NORWICH TO TILBURY

EN020027

Comments on Submissions received at Deadline 7

Suffolk County Council [REDACTED]

Drawing Number:	Revision:
10059280-ARC-EHR-ZZ-DR-ZZ-00432	A

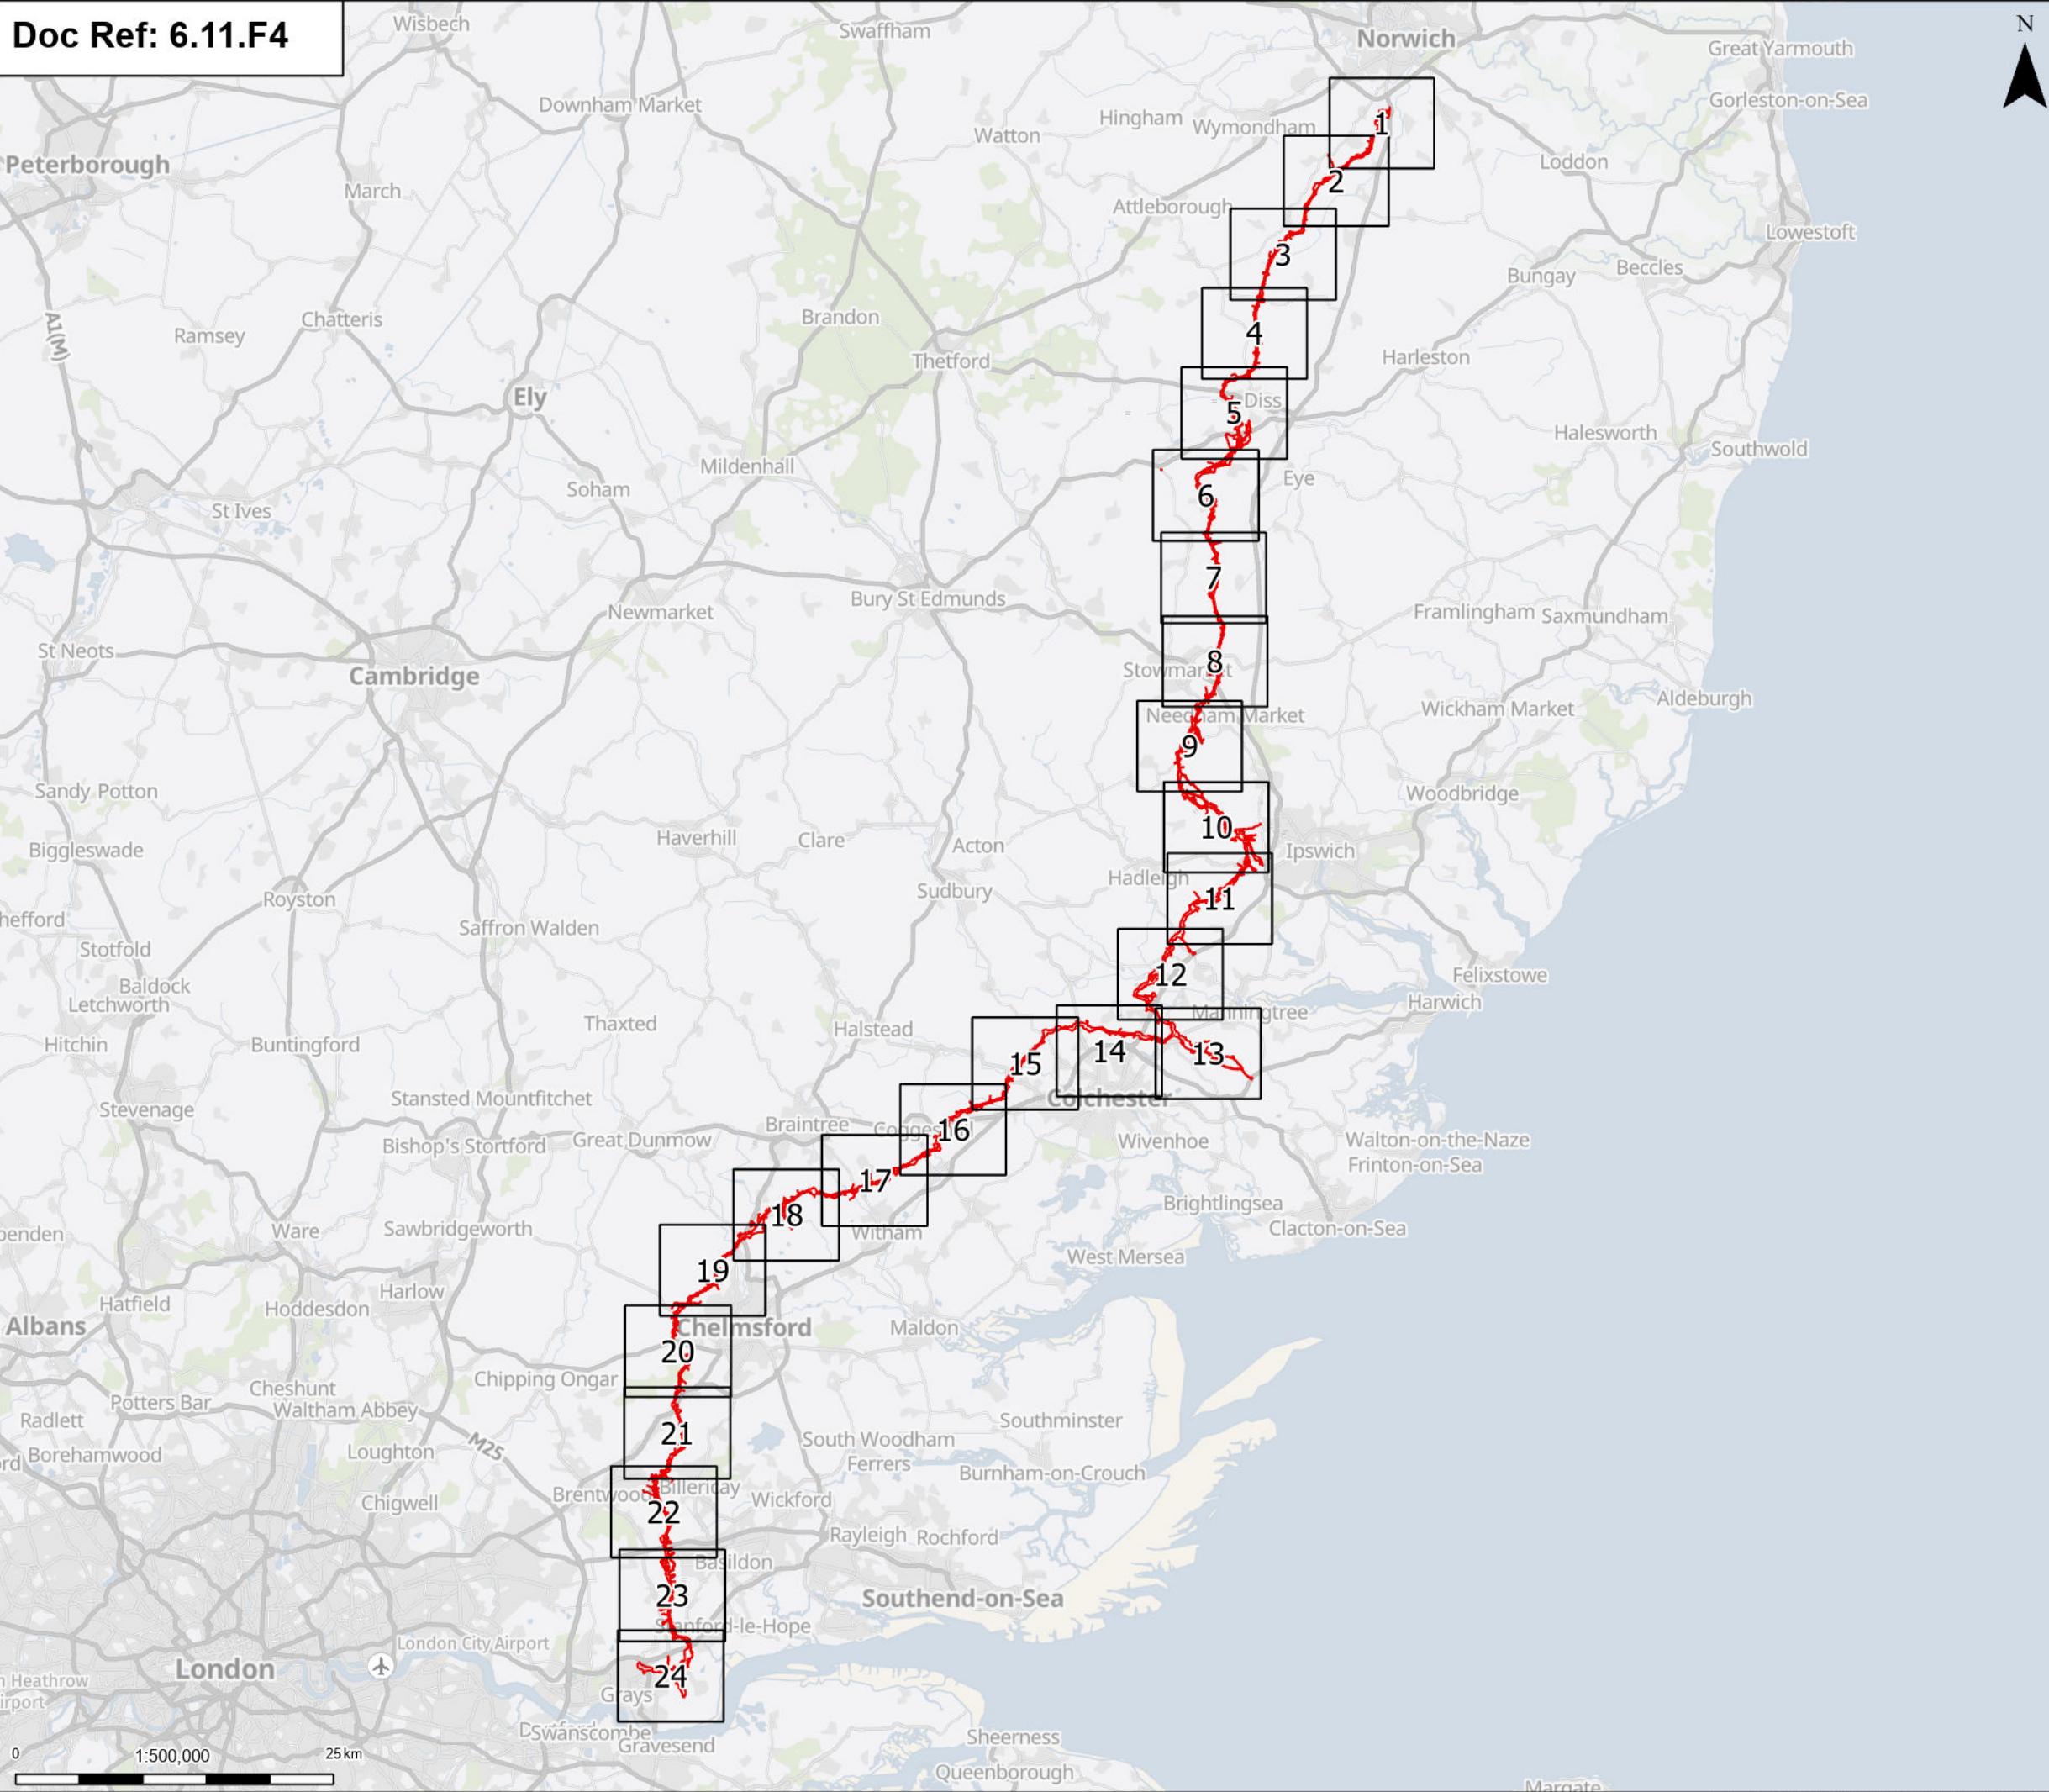
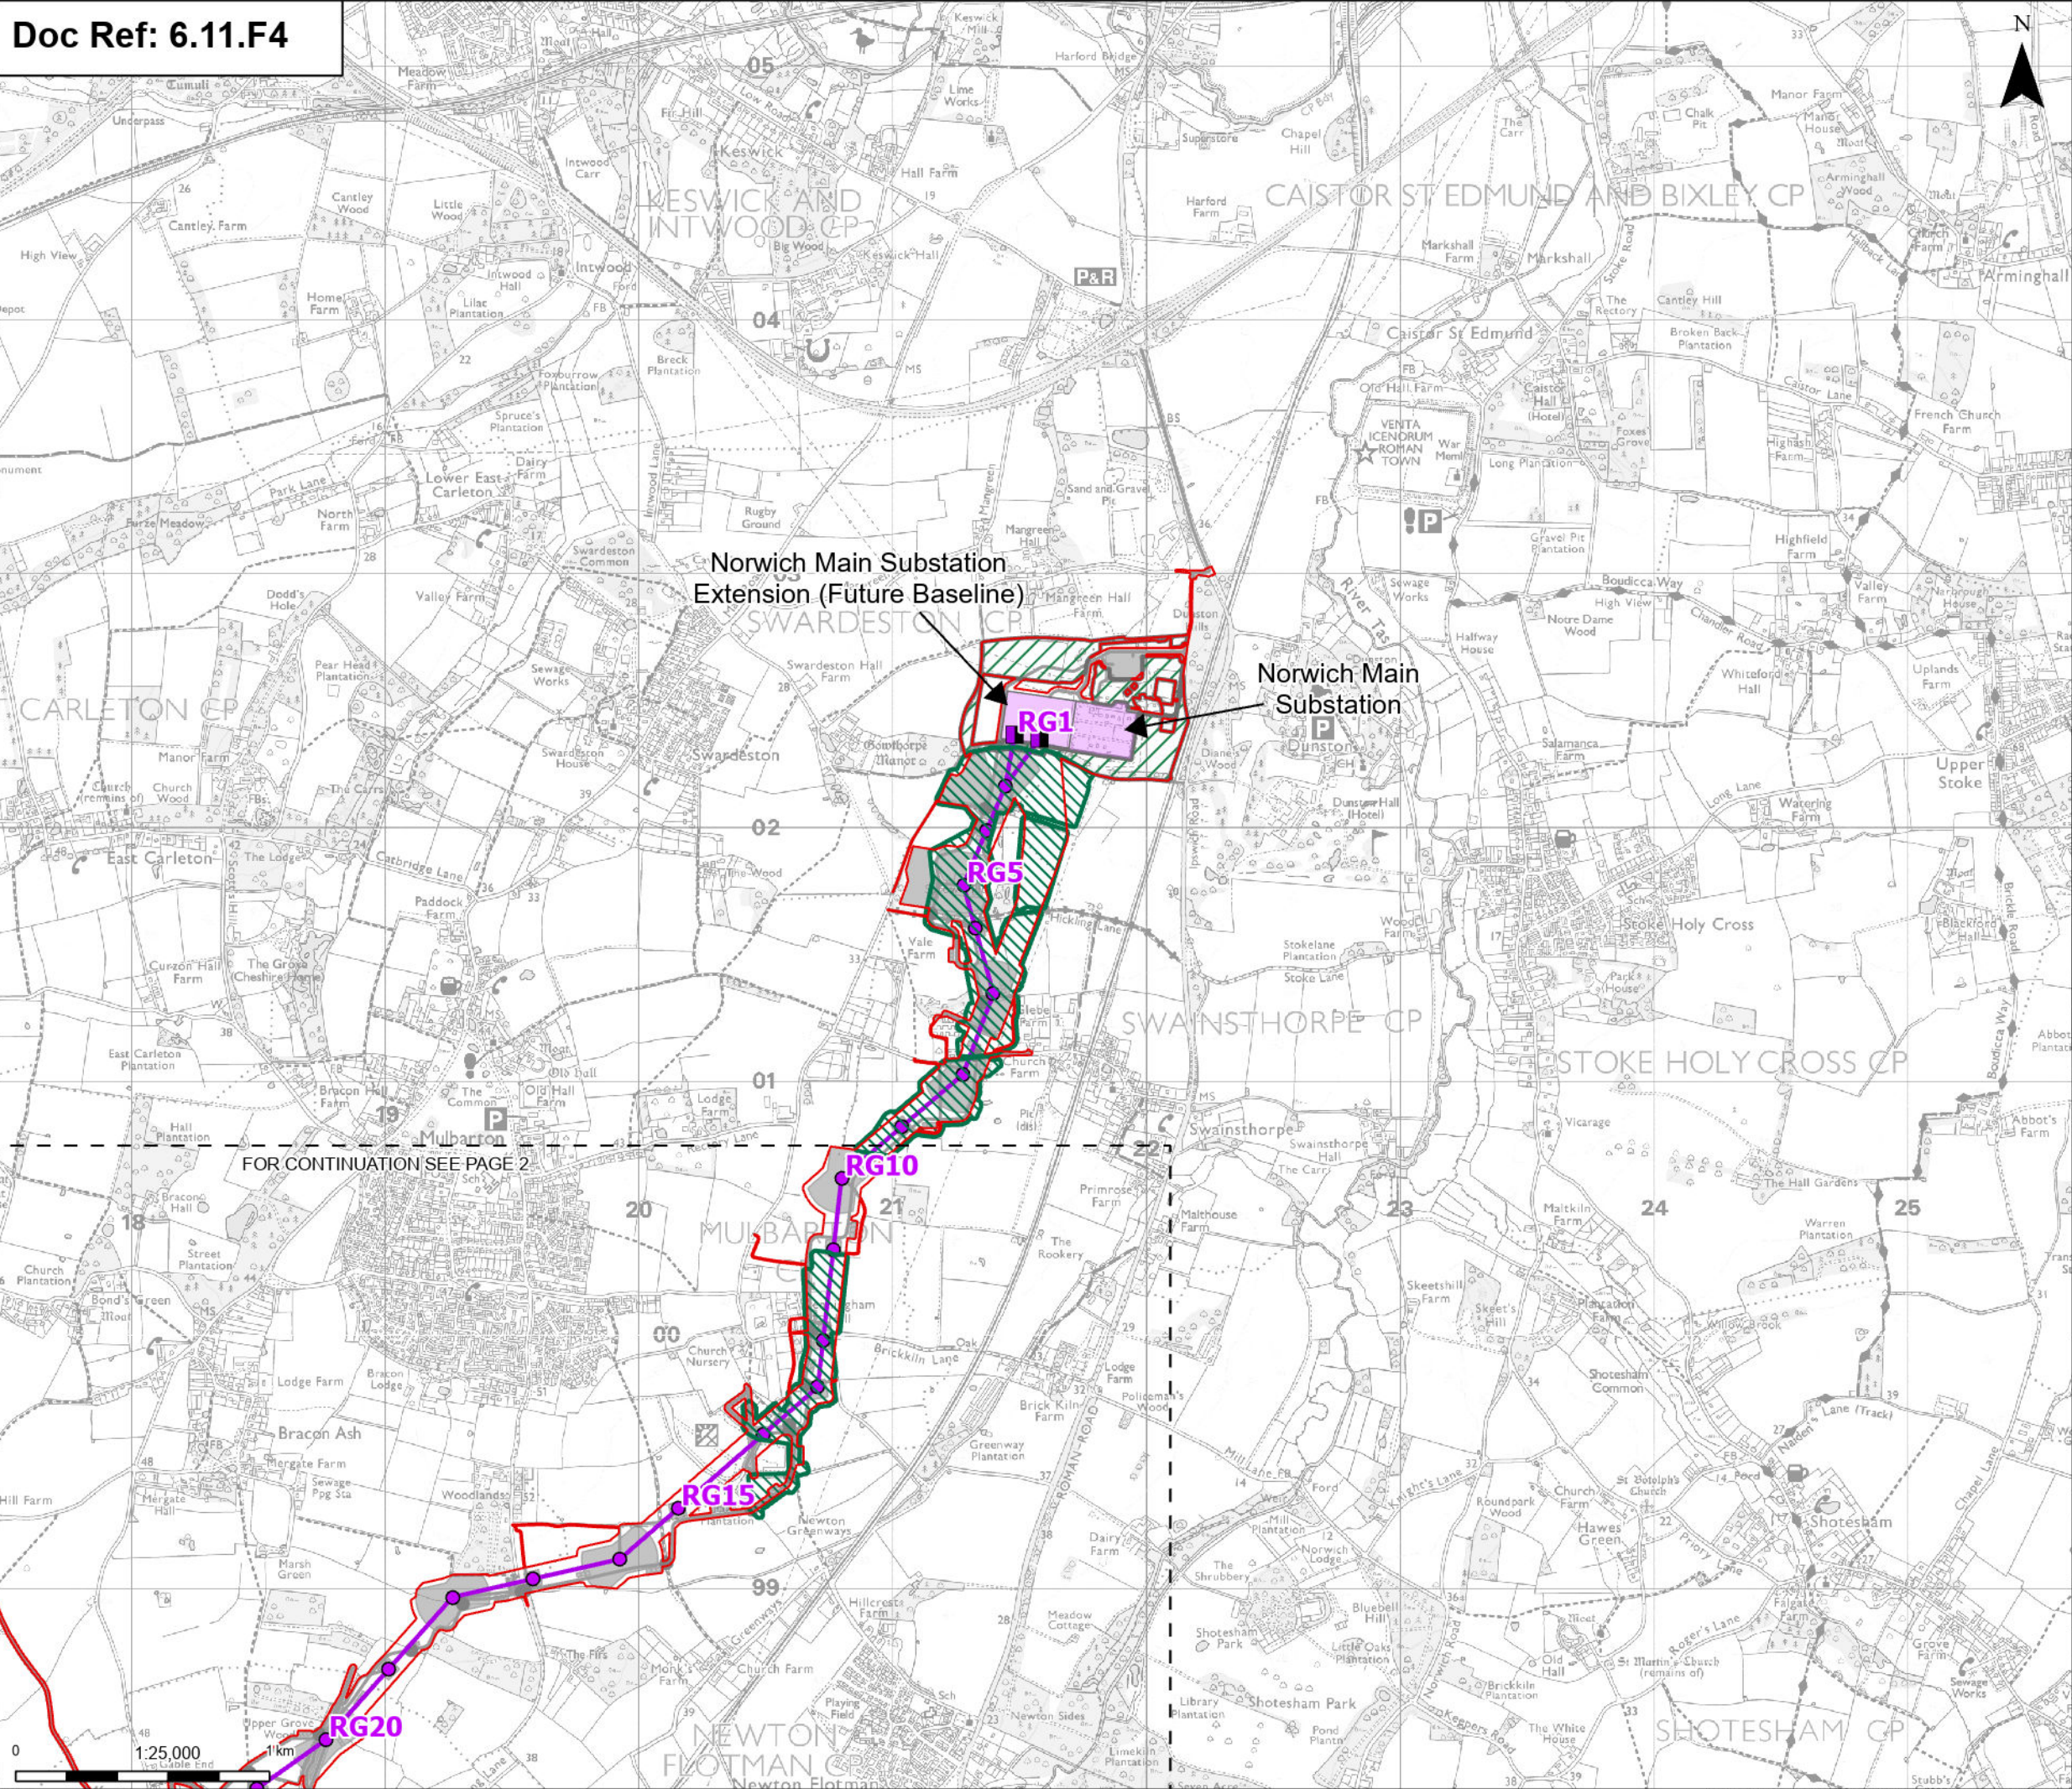
8.3	Archaeology	Figure 1 (Suffolk Sections B and C)	The title of the figure “<i>Progress of Priority geophysical survey, Priority archaeological trial trenching and Phase 2 geophysical survey and areas for Phase 2 archaeological trial trenching</i>” should be amended as follows: “<i>Progress of Priority geophysical survey, Priority archaeological trial trenching and Phase 2 geophysical survey and <u>indicative</u> areas for Phase 2 archaeological trial trenching</i>” SCCAS believe that all permanent accesses, SuDs ponds, 3rd party undergrounding of 132kV and 33kV should be depicted on the plan as requiring further archaeological assessment, evaluation and potential archaeological mitigation. Because these aspects of the scheme have the potential to seriously impact buried archaeological remains. Pulling areas should be highlighted as areas of potential construction impact to be informed by final design.
